KITTITAS VALLEY FIRE & RESCUE

KVFR Prevention Conditional Use Permit Comments

Vantage Valley Properties
Permit#: CU-24-00001
Date: 03/21/2024

CROSS VALLEY
 NATIONAL TRAINING
 CENTER
 SITE PLAN
 OCTOBER 9, 2023

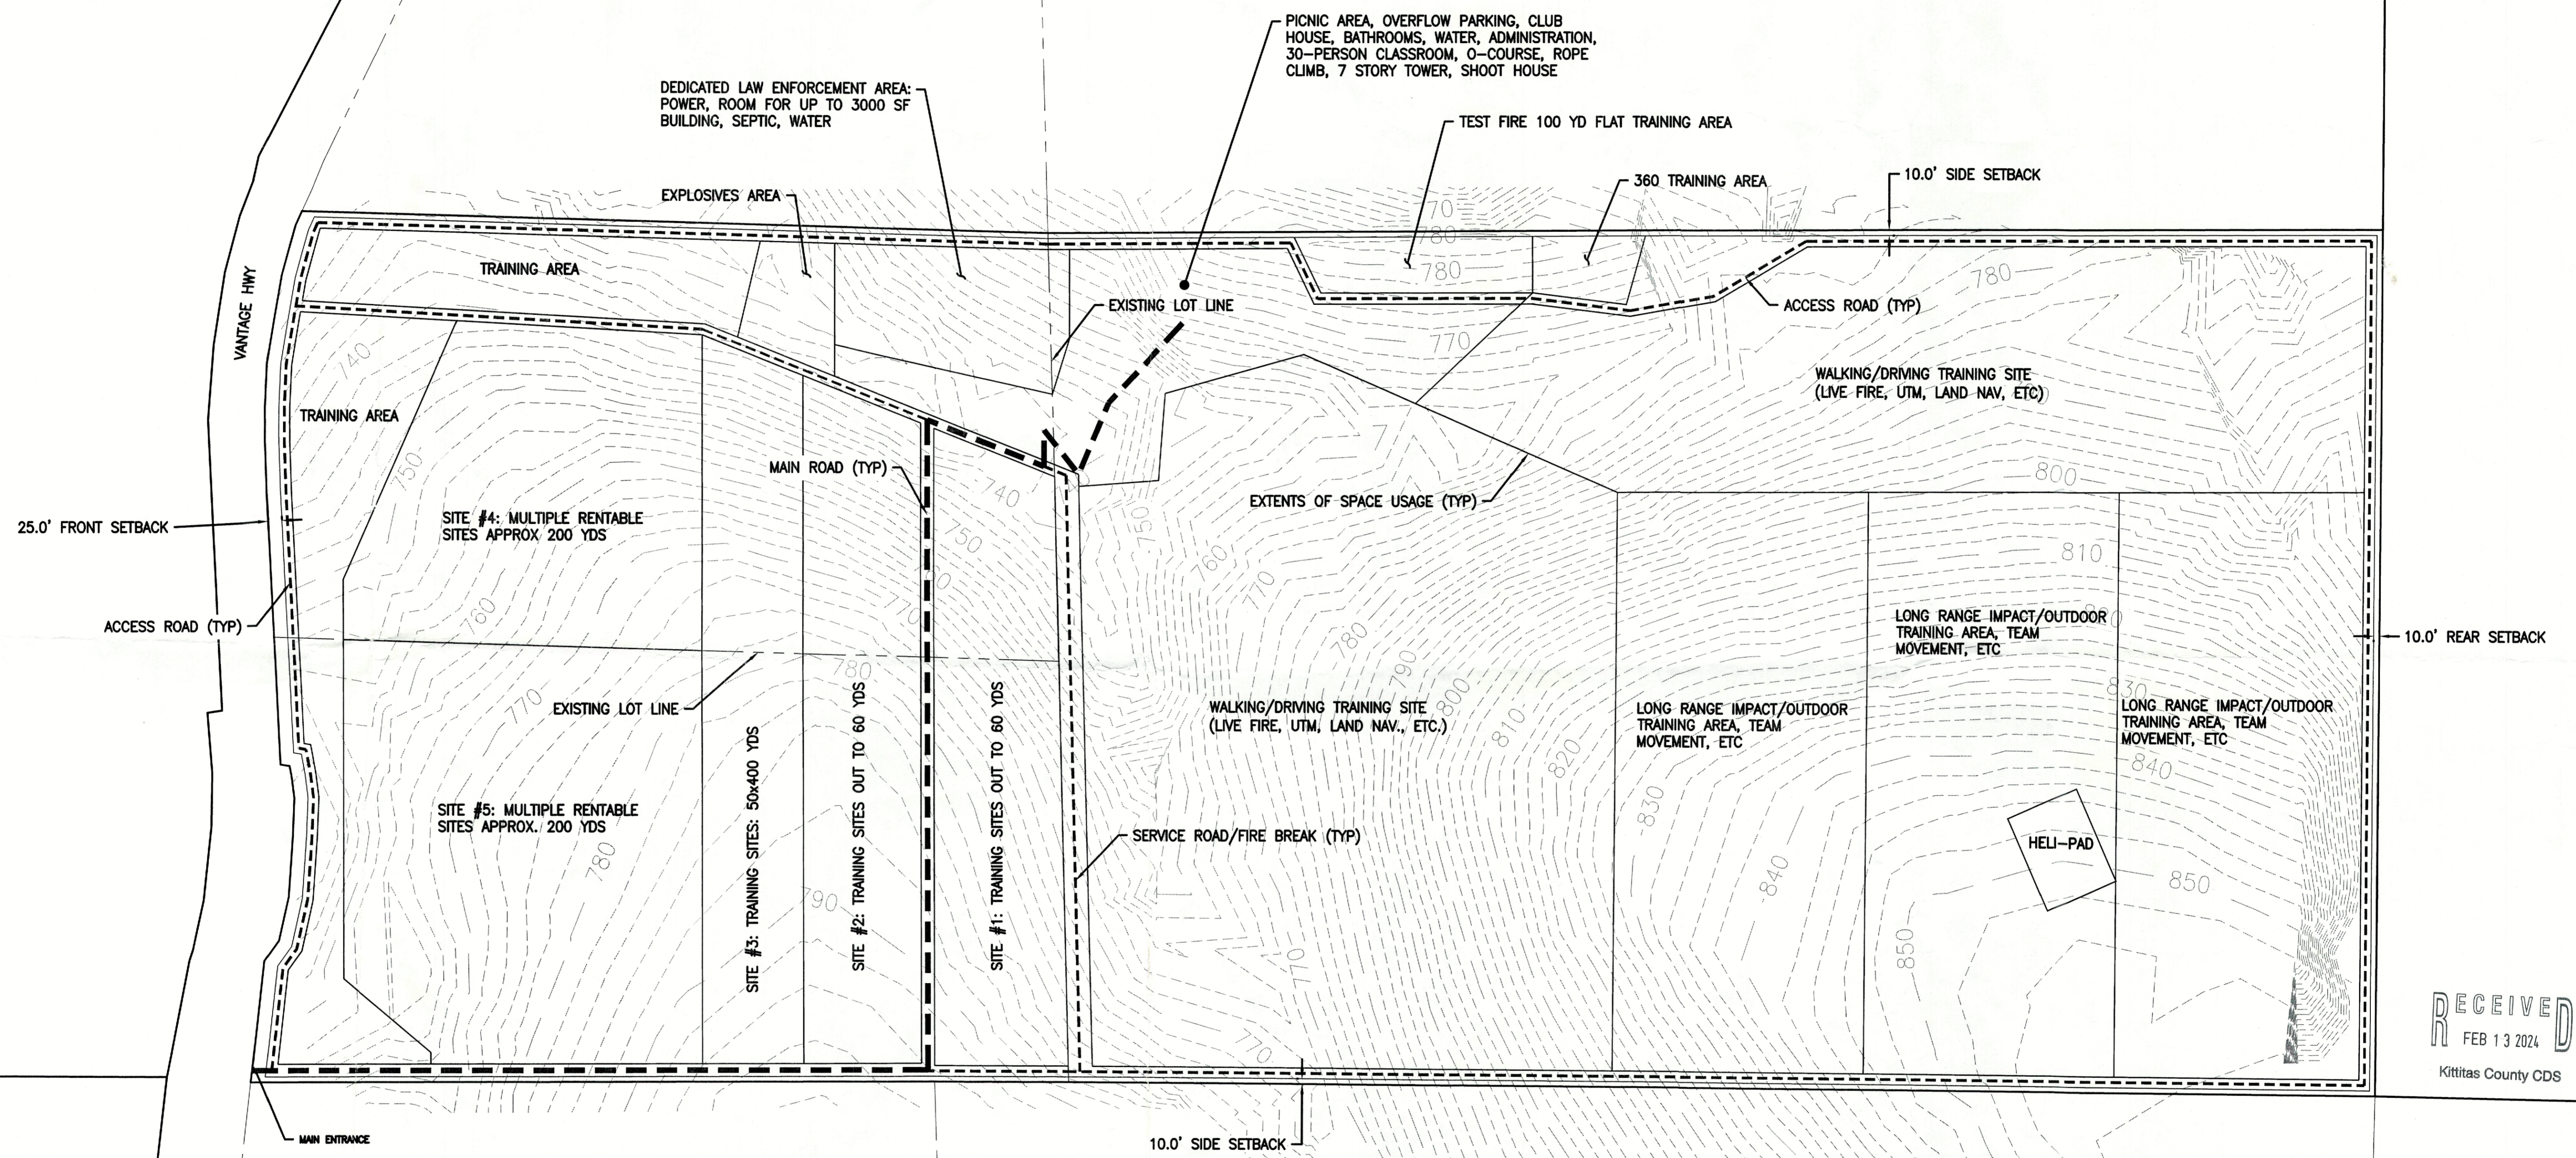
- Fire apparatus access roads exceeding 150' shall be provided with a temporary or permanent turnaround meeting the requirement 2021 IFC Appendix D.
- The IFC Appendix D requires the road be a minimum of 20' wide and capable of supporting an imposed load of at least 75,000 lbs.
- Buildings would be required to meet current IBC, IFC, WUI
- Our standard turning radius is a minimum of 23' inside and 45' outside.
- Water supply meeting Kittitas County requirements for fire protection.
